Hornsby Ku-Ring-Gai Hospital Stage 2 – State Significant Development Project (SSD 8647)

Response to Submissions Report
NSW Health Infrastructure
26 February 2018

Response to Submissions Report – SSD 8647 – HKH Stage 2 Redevelopment

APPENDIX 1 – NOISE MONITORING ALONG BURDETT STREET

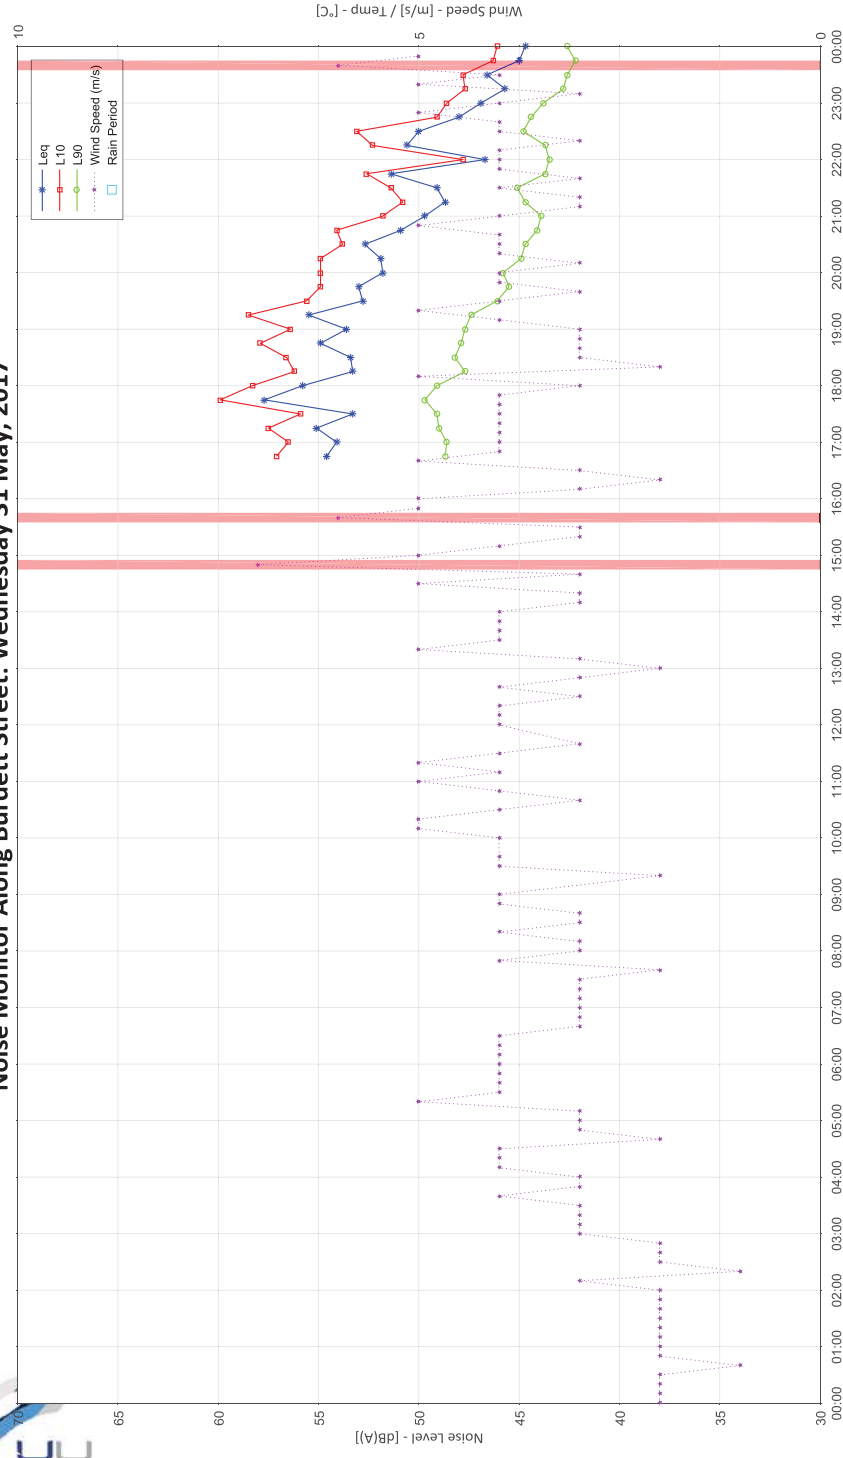
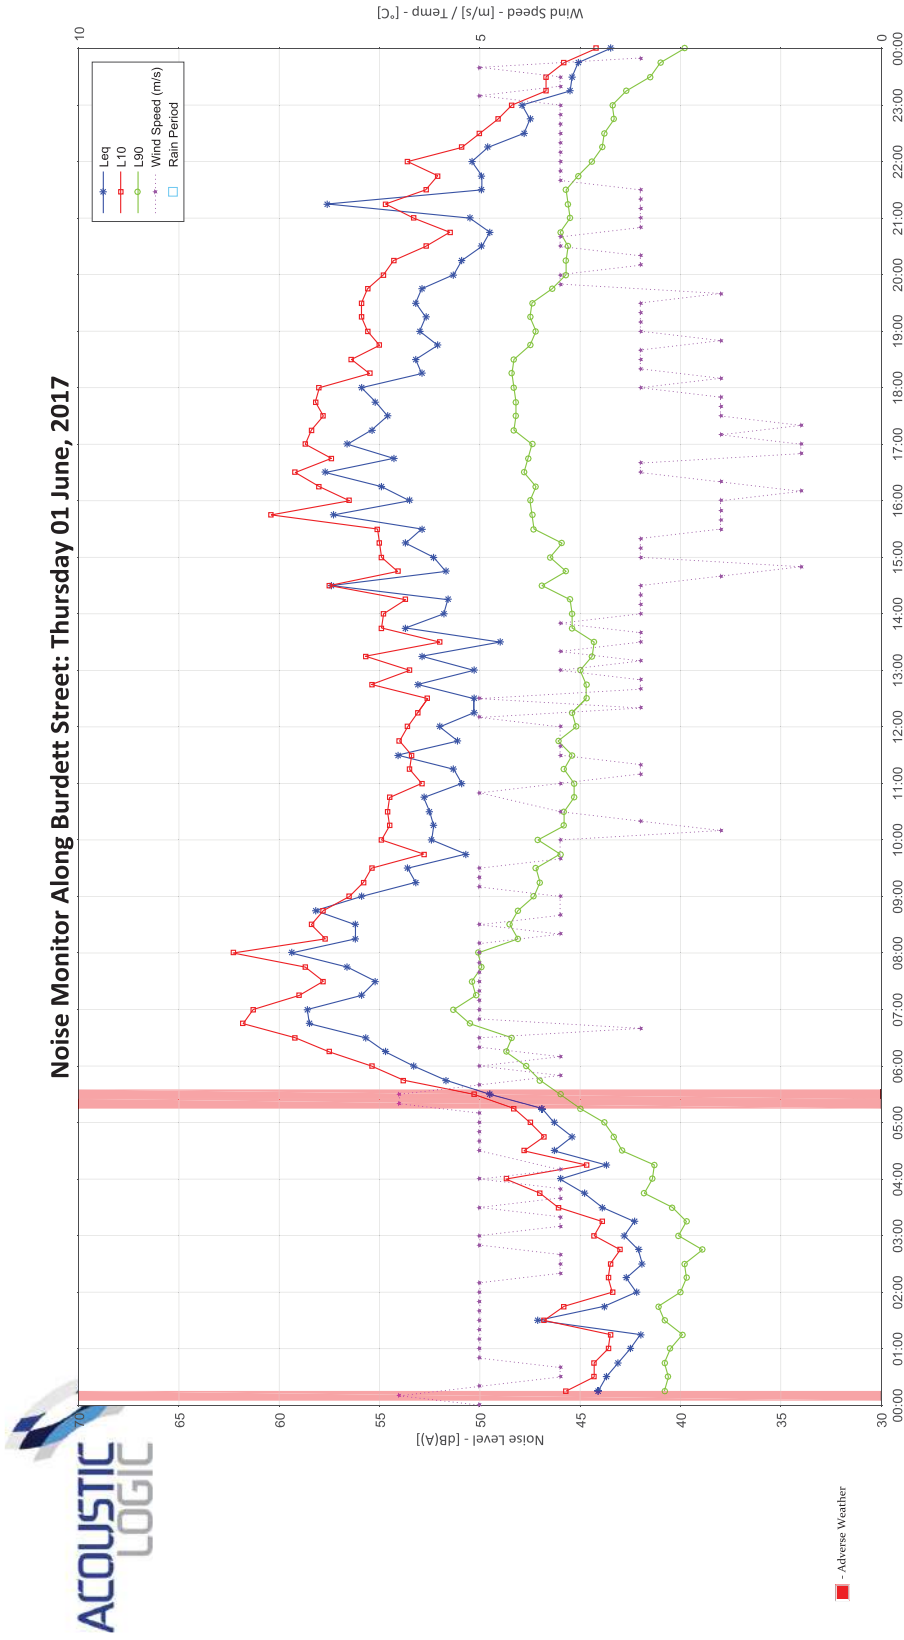
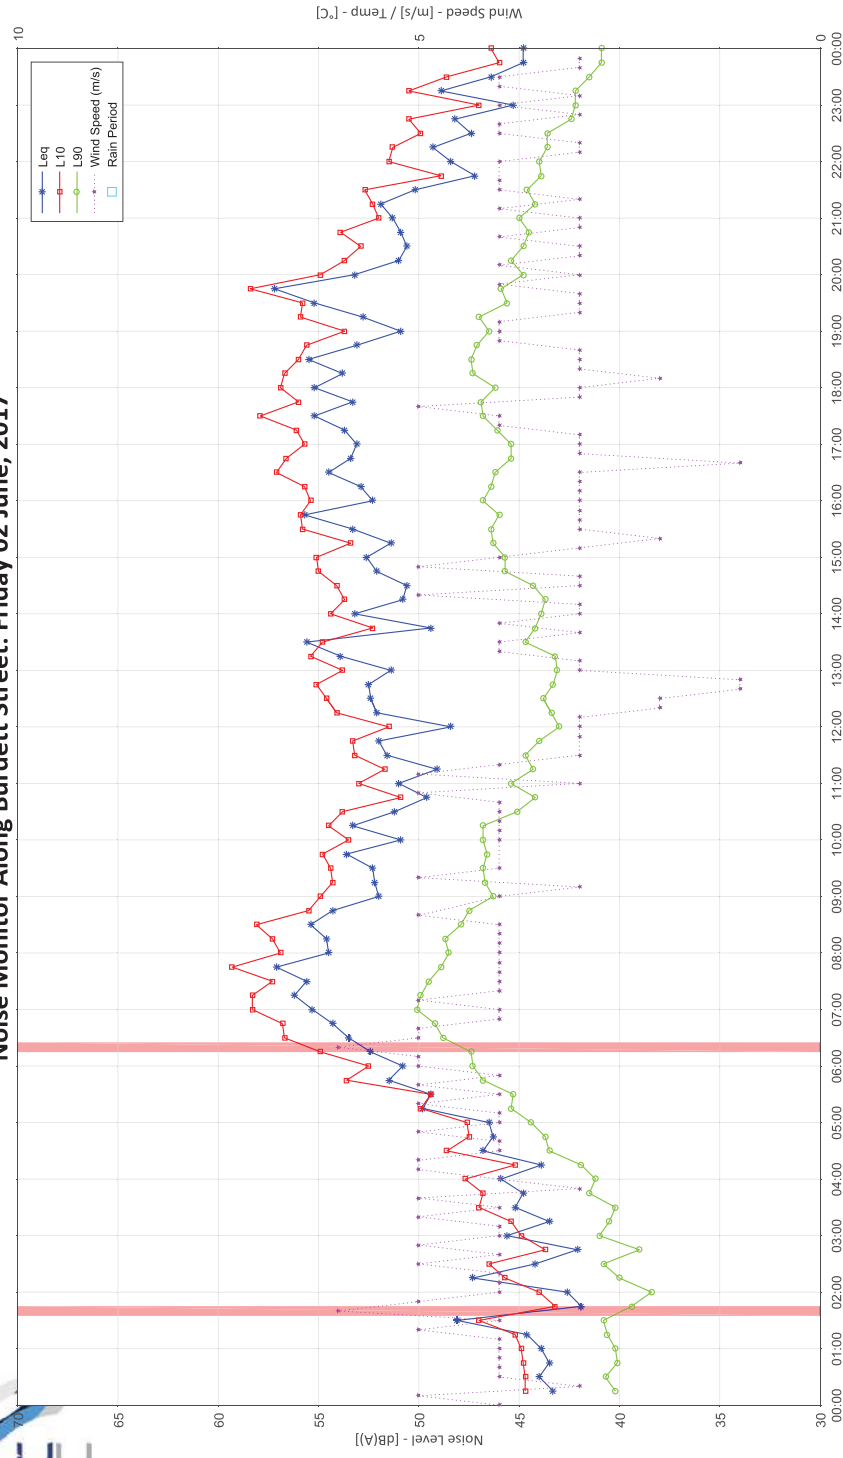
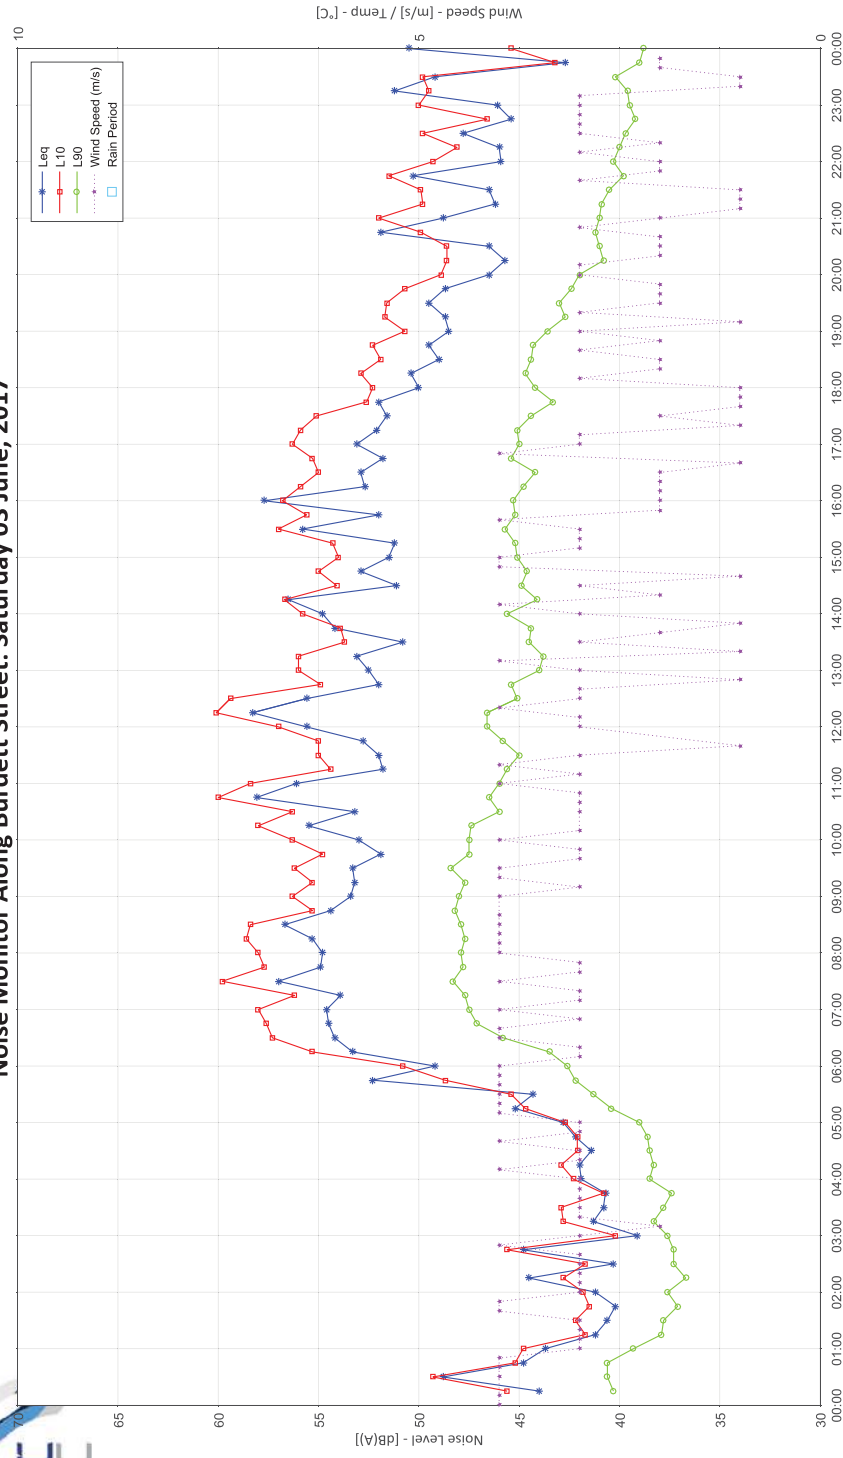
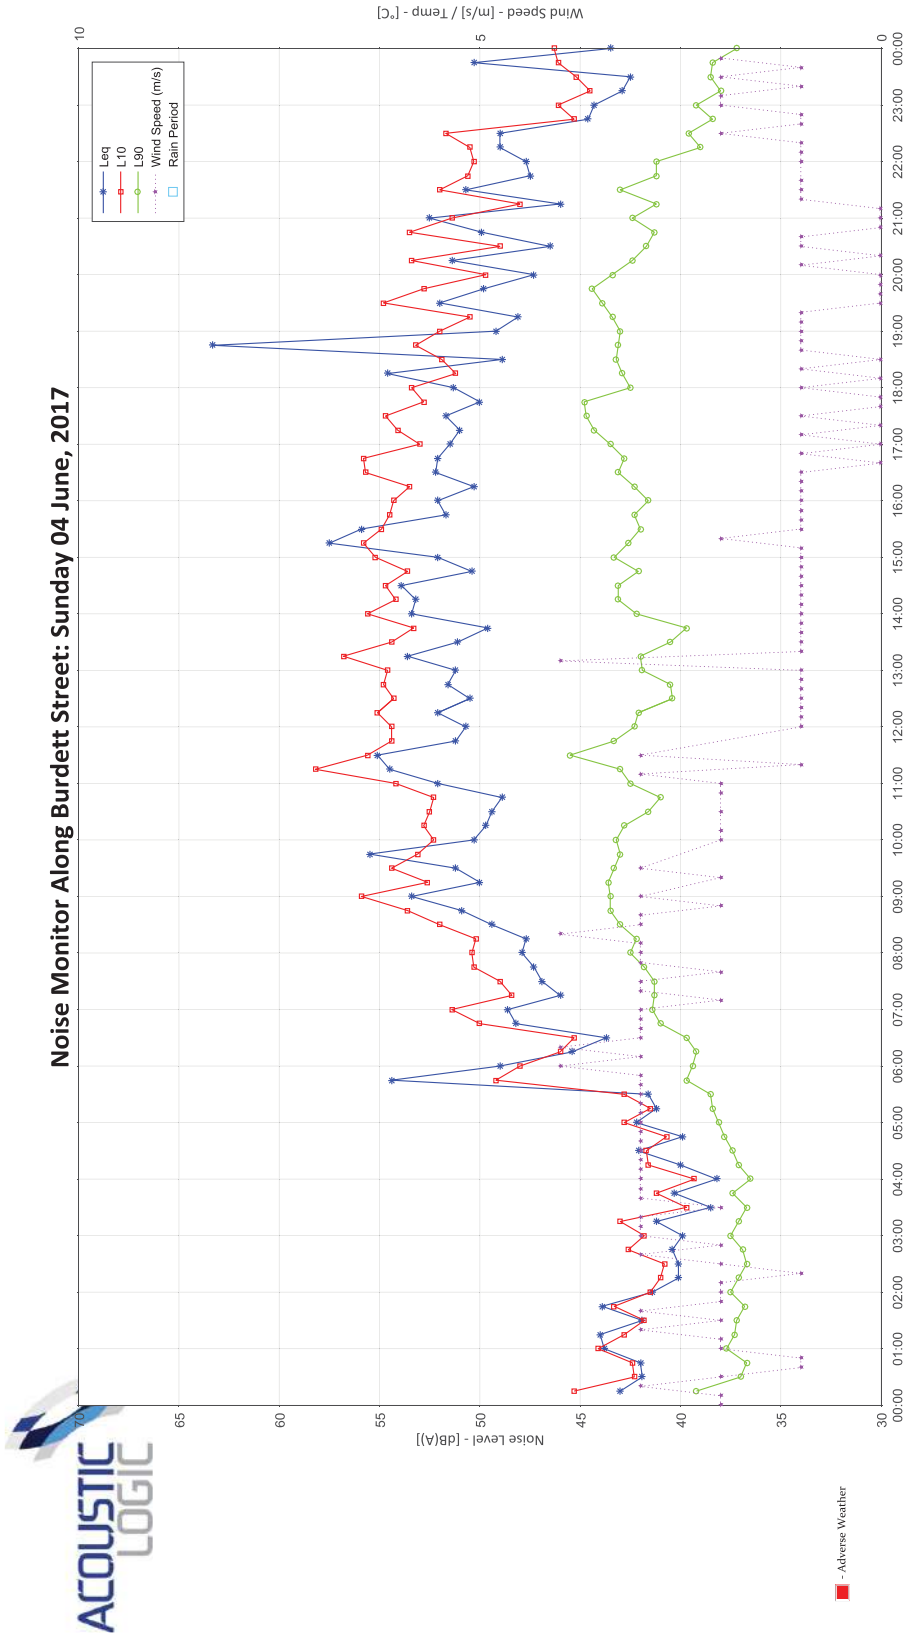
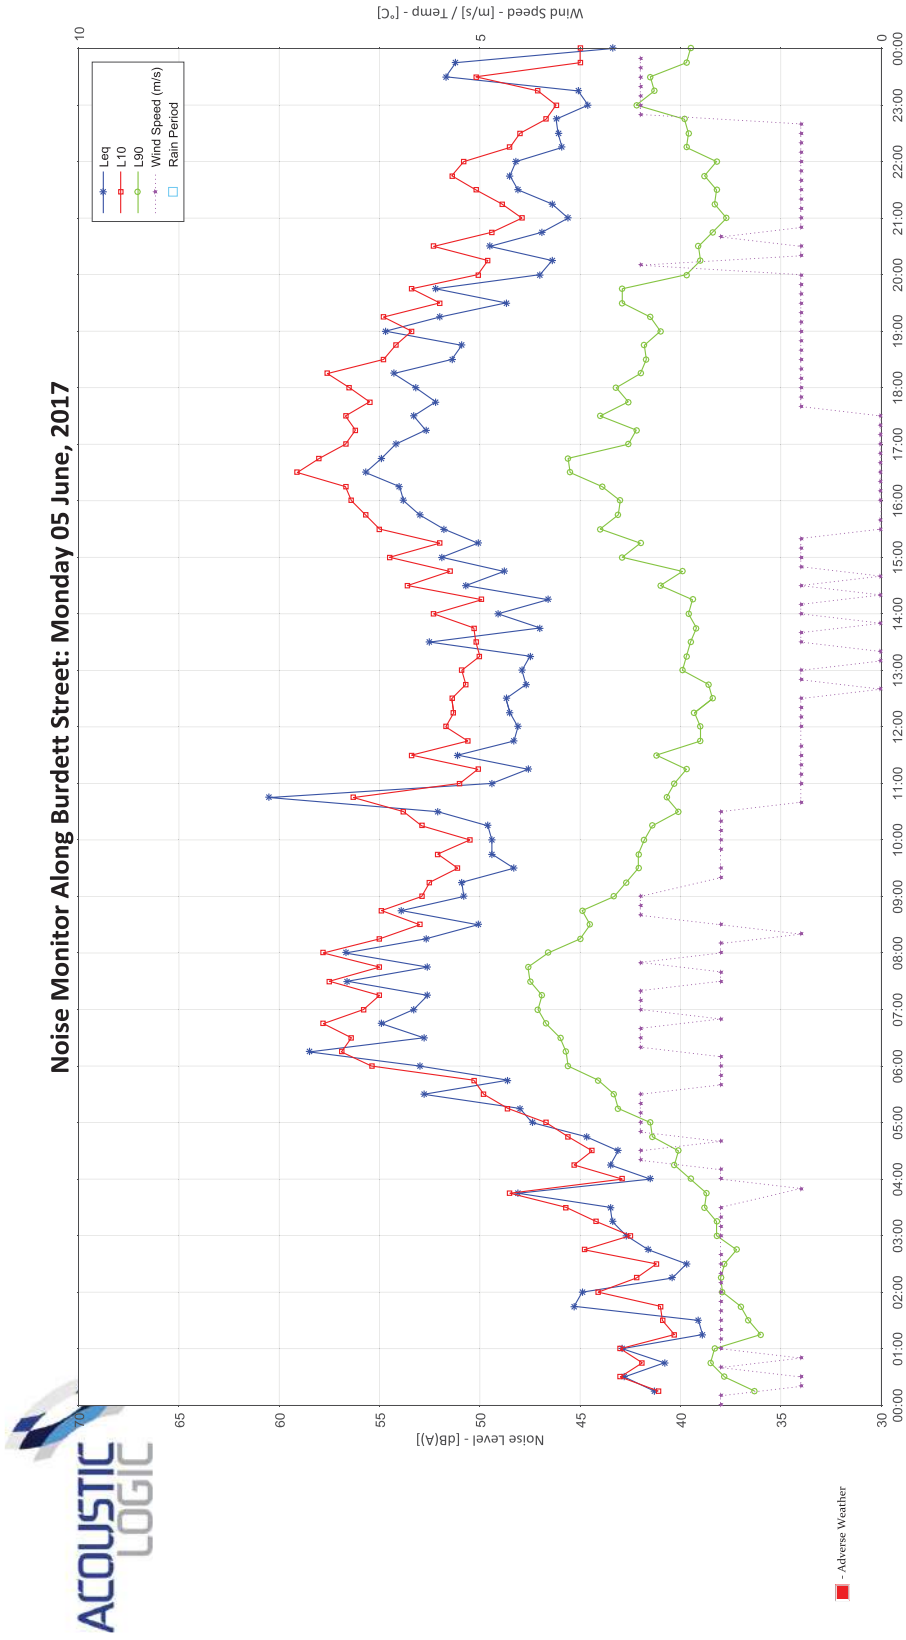
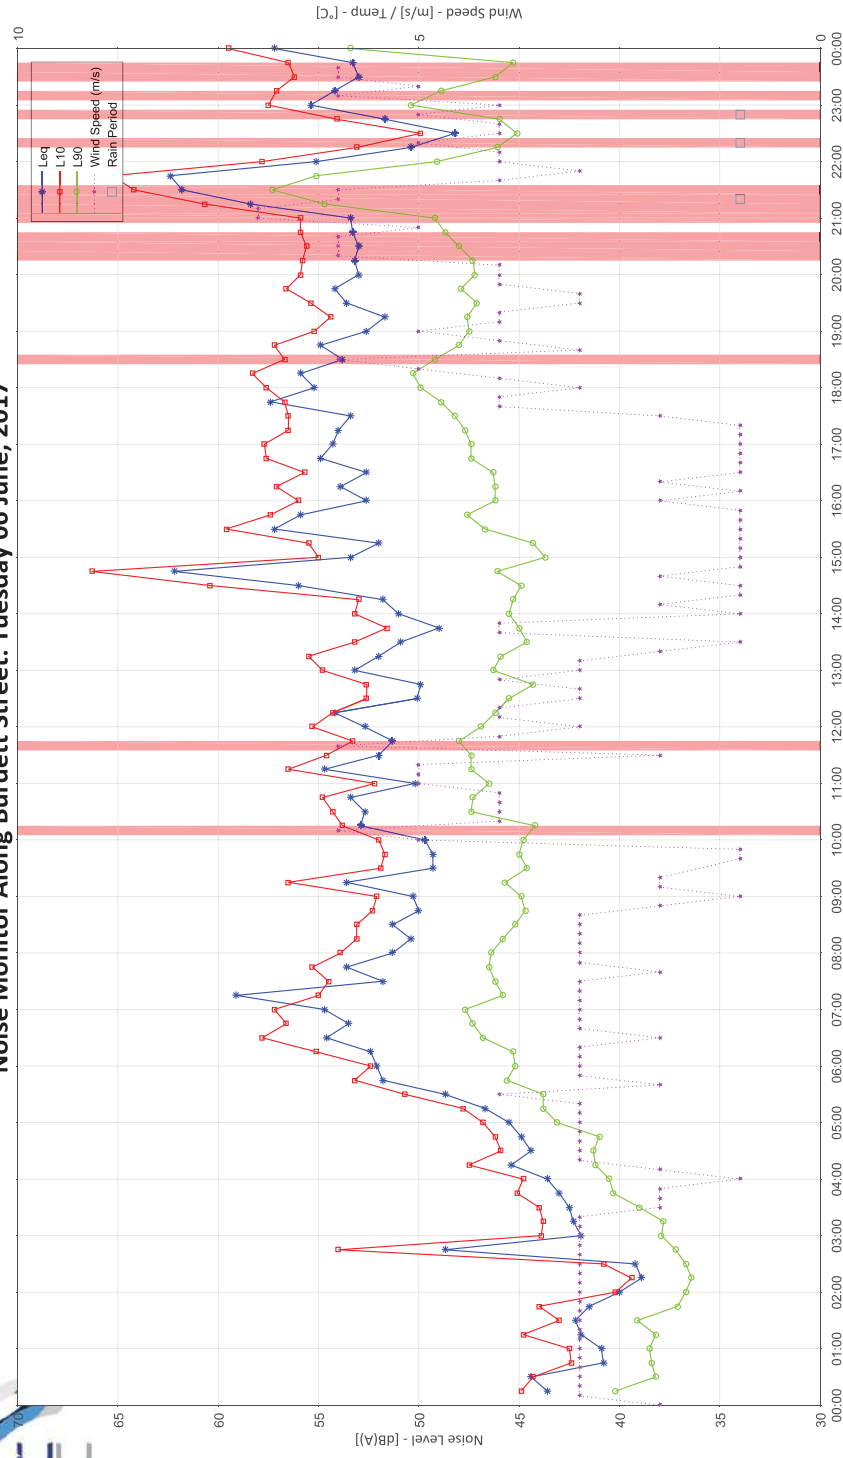
3.18	NSW EPA	The EPA has raised the following concerns with respect to the noise monitoring graphs in Appendices 1-3 of the Acoustic Assessment: (a) the legends to some monitoring graphs appear to be misaligned (e.g. wind speed, rain period), (b) the legends to monitoring graphs includes a blue marker for 'rain period' and although rain was observed on several days during the various monitoring periods (i.e. 24 May to 7 June 2017), no rain periods are represented in the graphs, and	As per Item 3.15 .	Appendix J – Revised Noise Impact Assessment

ITEM	LETTER	MATTER RAISED	RESPONSE	REFERENCE
		(c) some of the monitoring graphs include sections of red highlight, but there is no red marker in the legend to those graphs to identify the meaning of those red highlighted periods, and (d) Appendix Q does not appear to identify when noise monitoring loggers were last laboratory calibrated which brings into question reliability of the recorded data.
